# Consultee Comments for Planning Application 20/03665/PLF

Application Number: 20/03665/PLF

Address: Land North Of 13 Hazel Avenue Withernsea East Riding Of Yorkshire HU19 2PQ

Proposal: Erection of a dwelling and garden store

**GROUND FLOOR LAYOUT PLAN**  
PROPOSED - SCALE 1:50

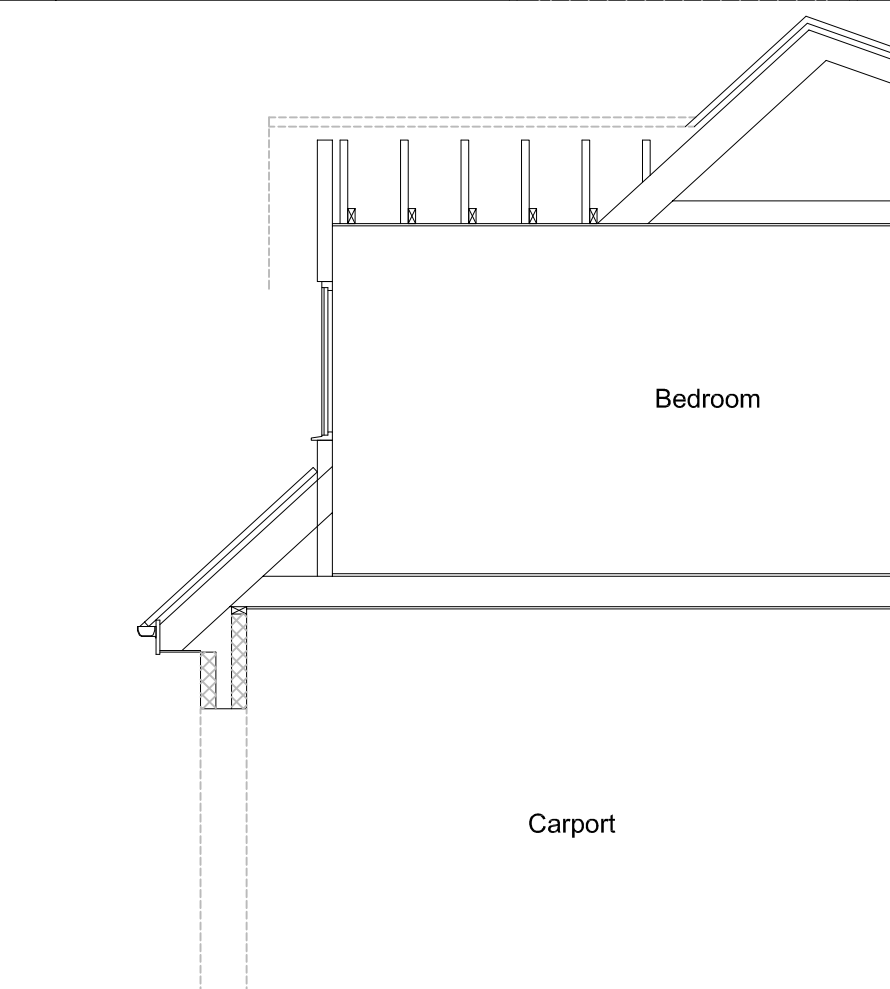
The submitted planning application form suggests that the proposal includes parking provision for 4no parking spaces. While the porch/garage can be considered as provision for 1no. parking space, its internal dimensions are required to be altered to at least 3m wide and 6m long in order to meet the requirement of the MfS 2007. The area at the front of the proposed dwelling has sufficient space to accommodate 2-3 parking spaces however the indicative layout of all proposed parking spaces is required to be shown. Therefore an amended proposed Location Plan and Proposed Site Plan are required to show above information in order to allow full assessment of access and parking in accordance with the MfS and the SPD of the ERLP.

AMENDMENTS 2B (20.10.20) Amended for client 2C (28.10.20) Amended for client 2D (4.11.20) Amended for client 2E (21.11.20) Amended for DC	DRAWING No. ELDON 08 2020 2E SCALE 1:200 & 1:1250 @ A2
---	---

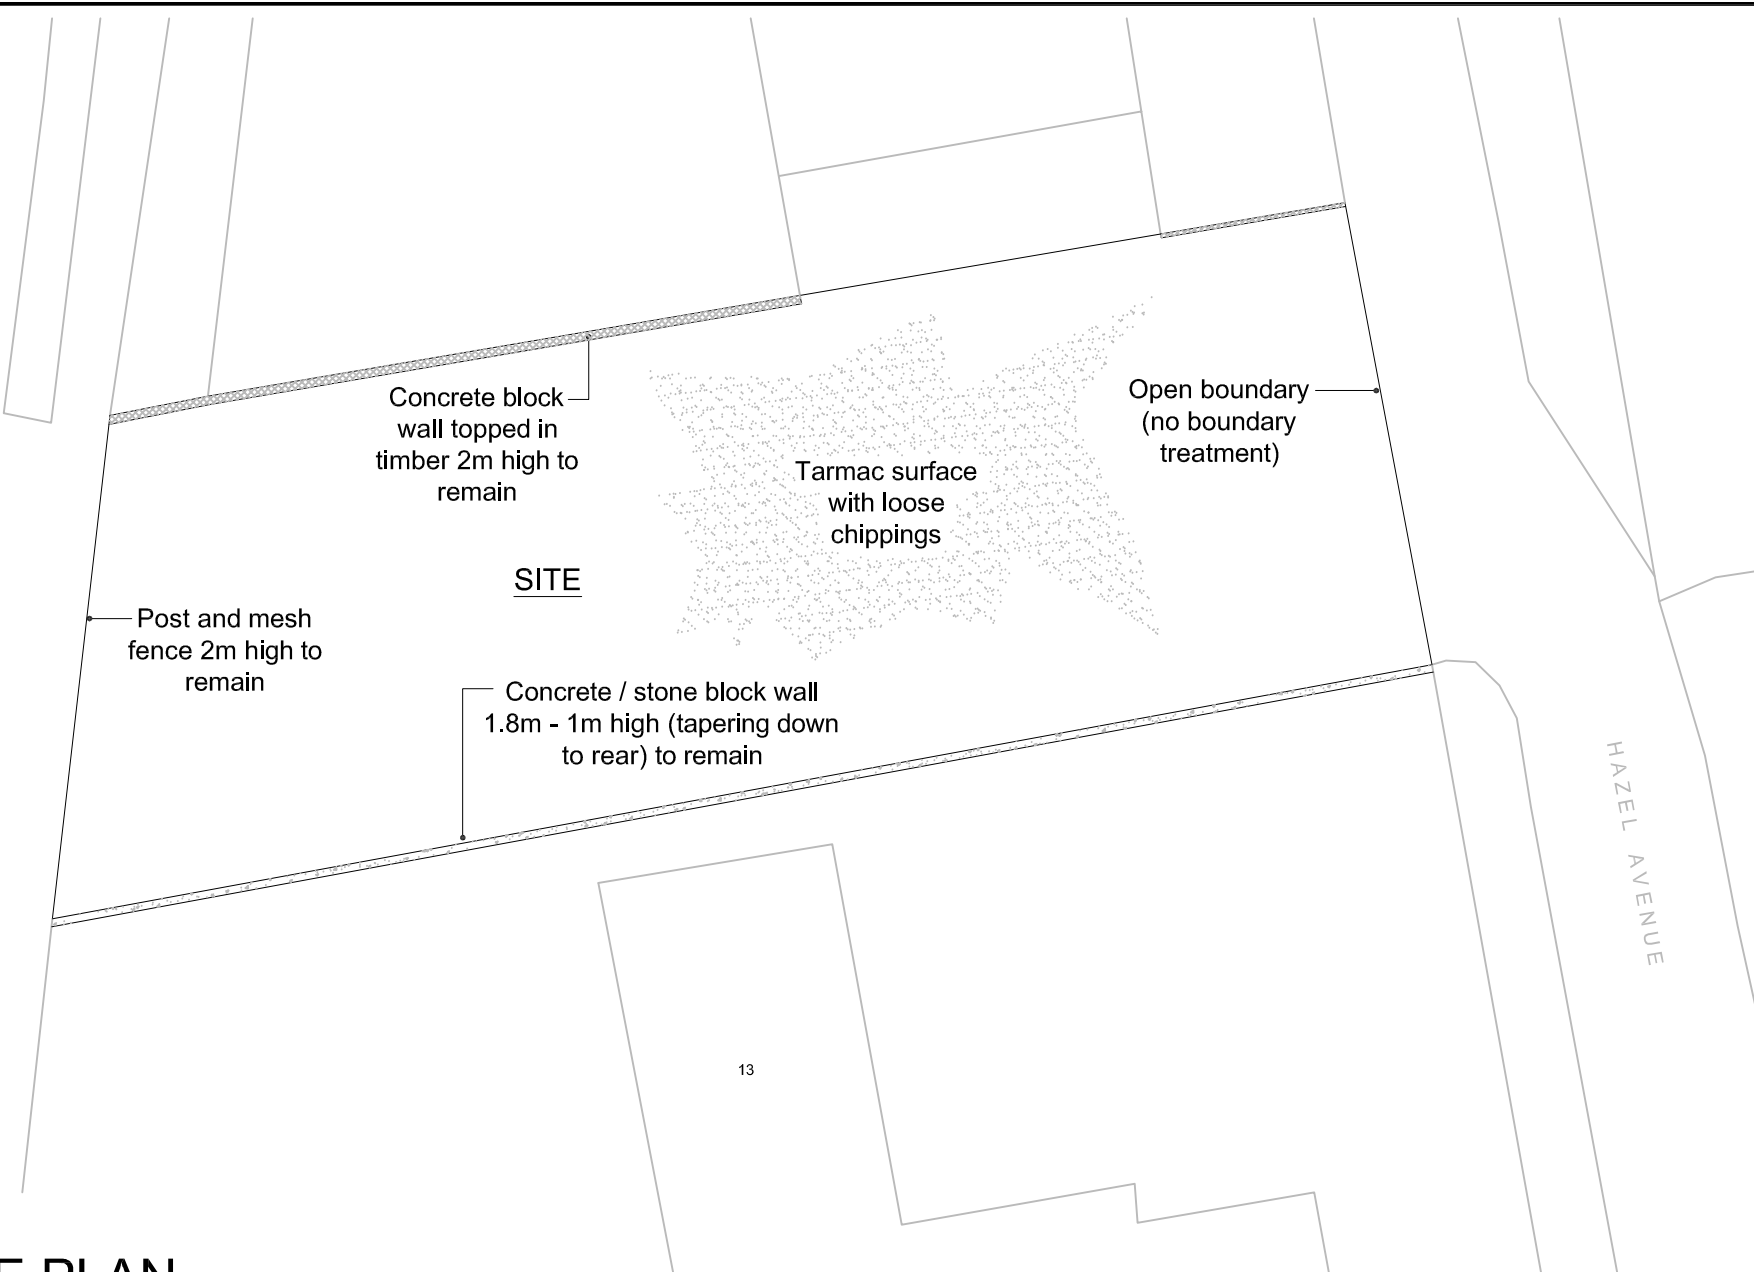
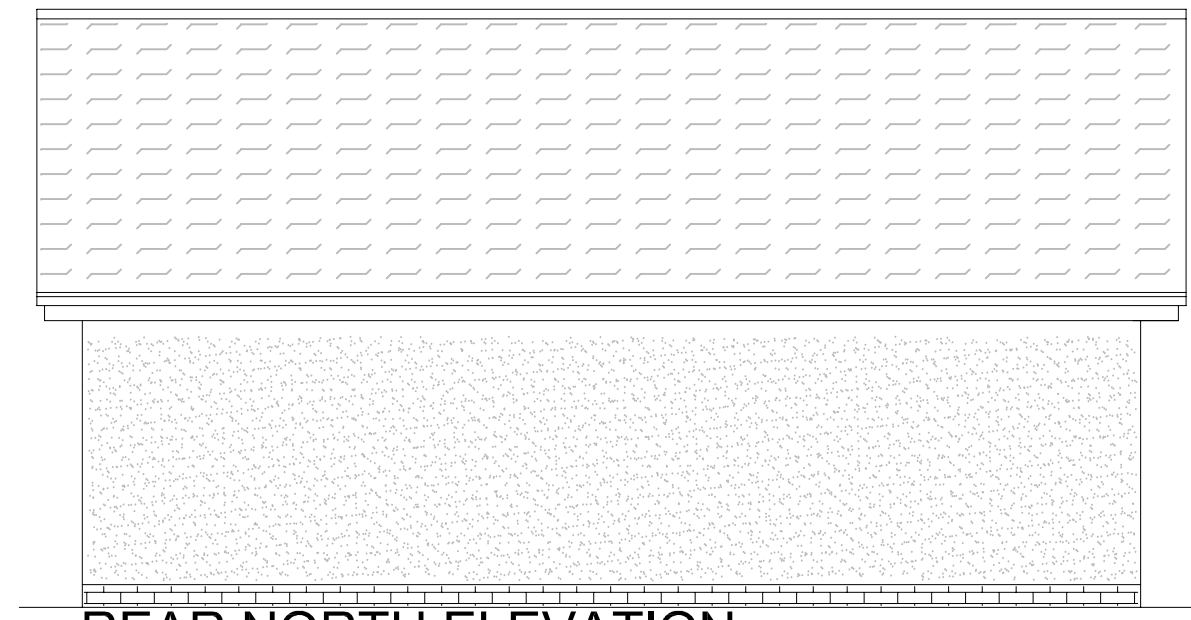
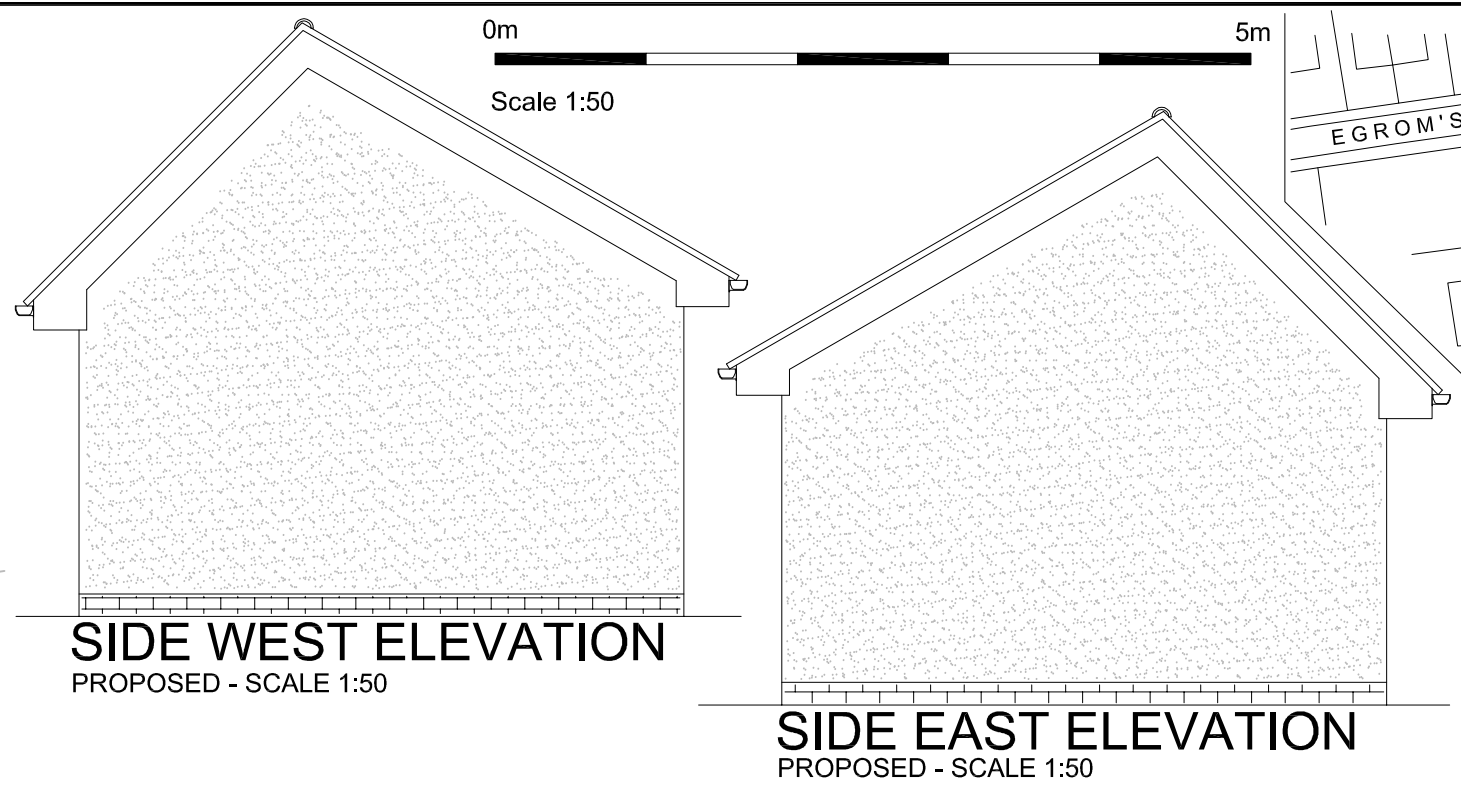
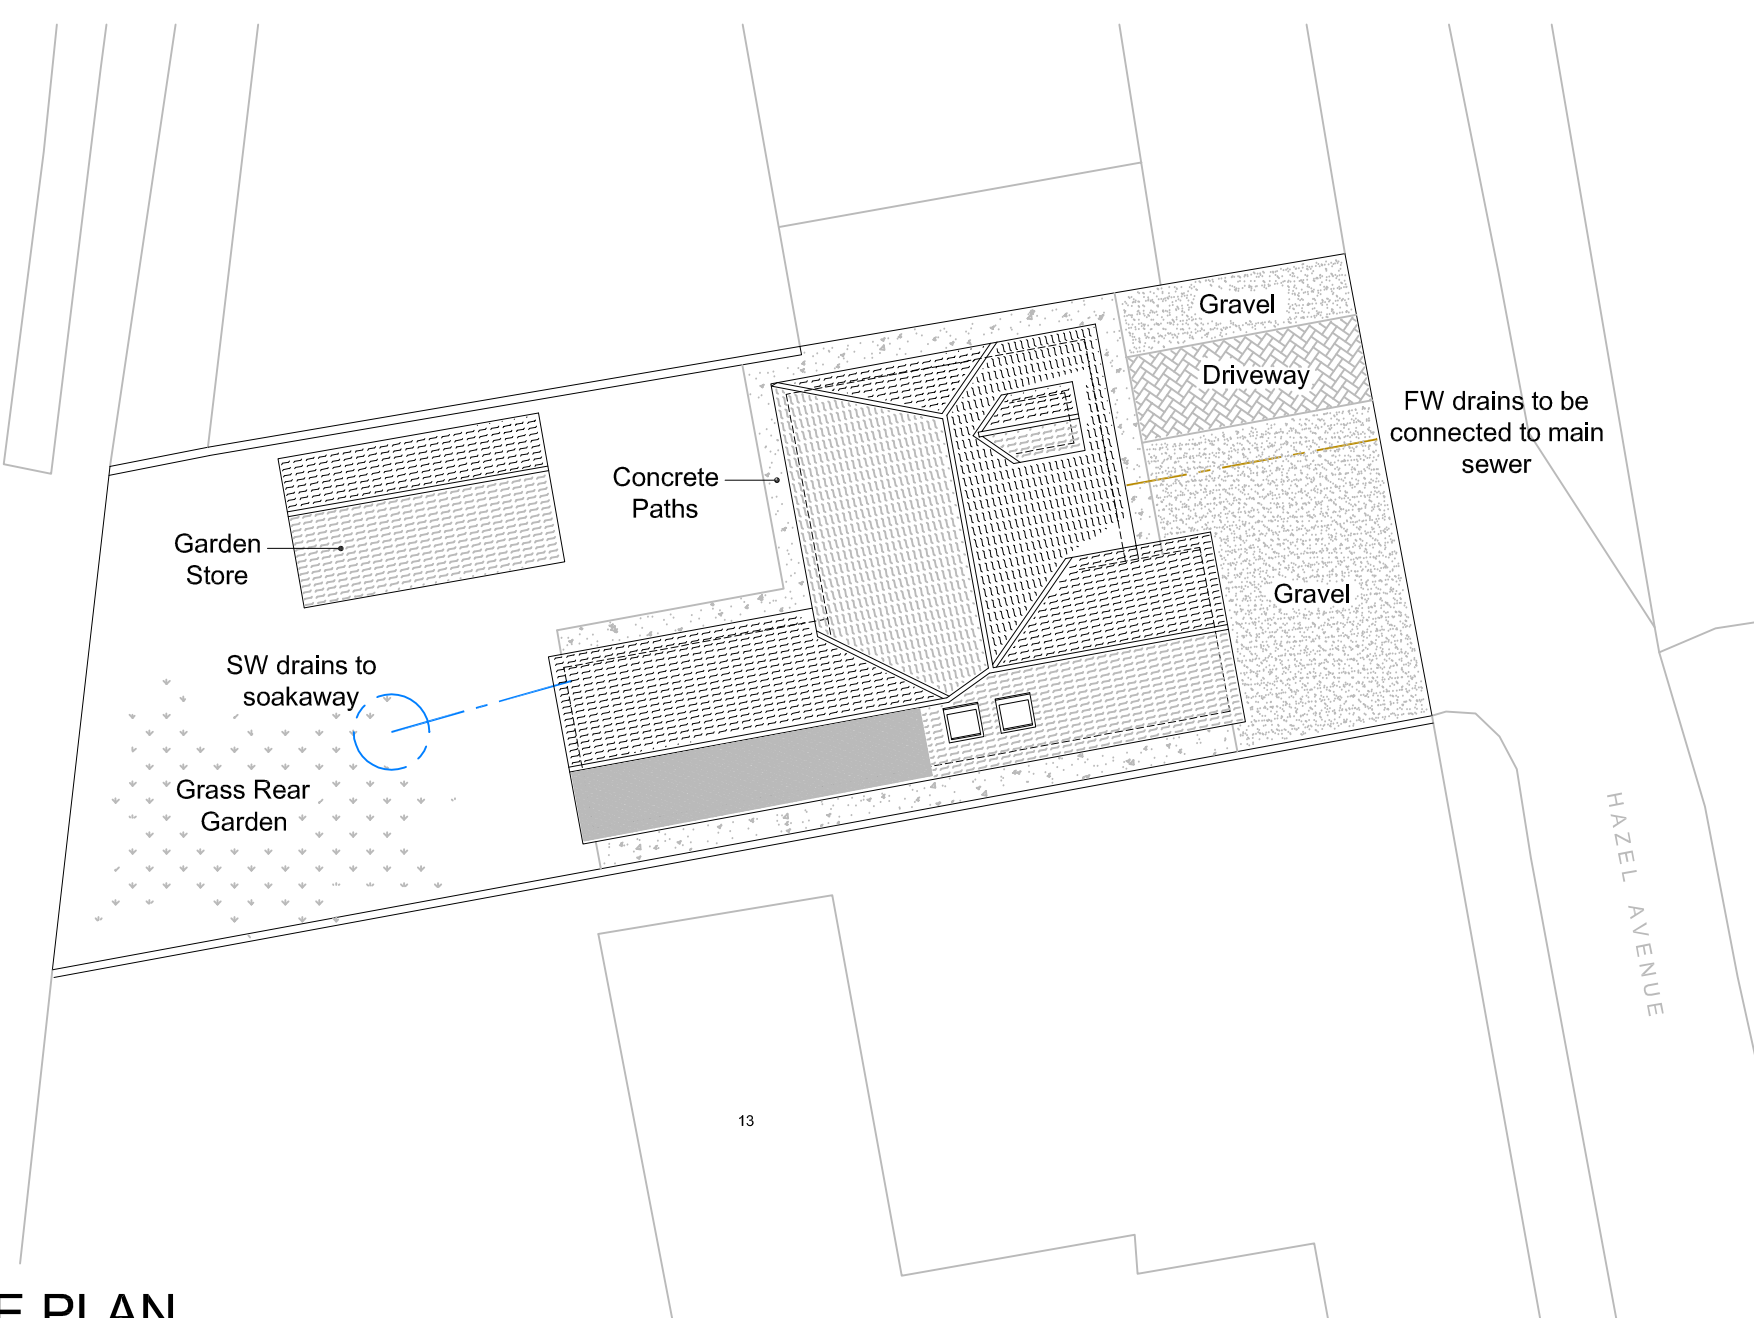
Drw.No ELDON 08 2020 2E shows Proposed Site and Location Plans. While the location plan doesnt show the full extend of the red line which should include part of Hazel Avenue (private road) joining Chestnut Avenue (unclassified, adopted carriageway) the proposed access (outside No 11) and the details of the driveway entrance as to its width are also not shown on the proposed site plan.
